Initial Application Date: 11/16/01

Application #: 01-5000 3469

COUNTY OF HARNETT LAND USE APPLICATION

LANDOWNER: HAILEY JAMES & MARY

### SITE PLAN APPROVAL

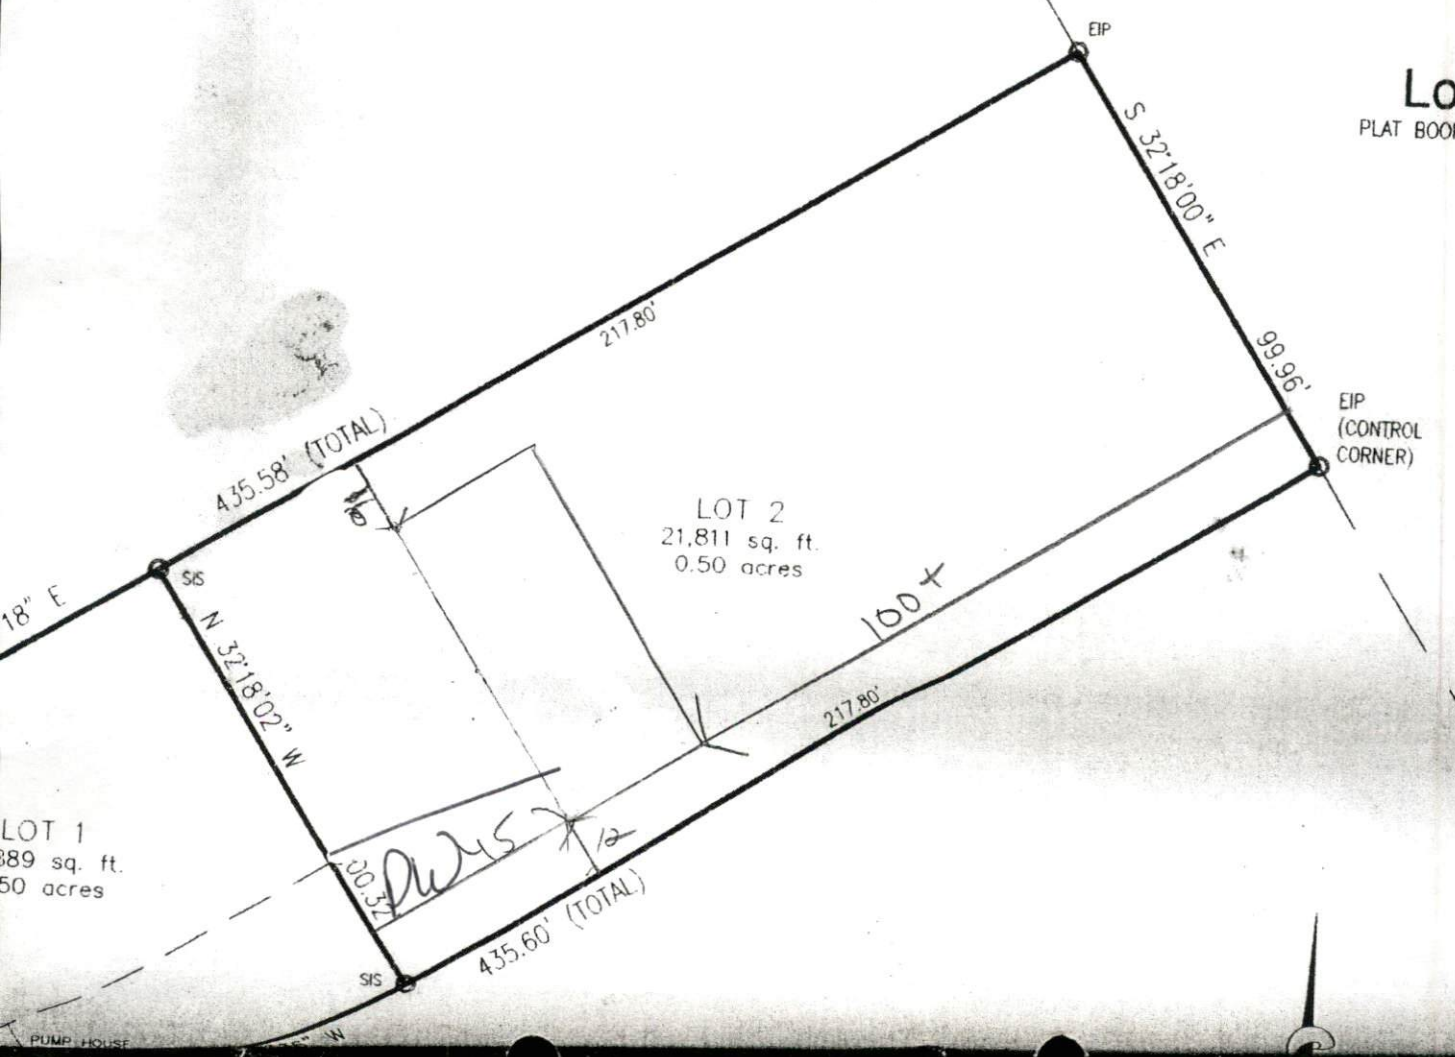
Move house Back

Must meet
meet
DNJ.k
for Final
Layout

House is not
Move Back 6'. from
Front P/L Pump to LPP
will be required
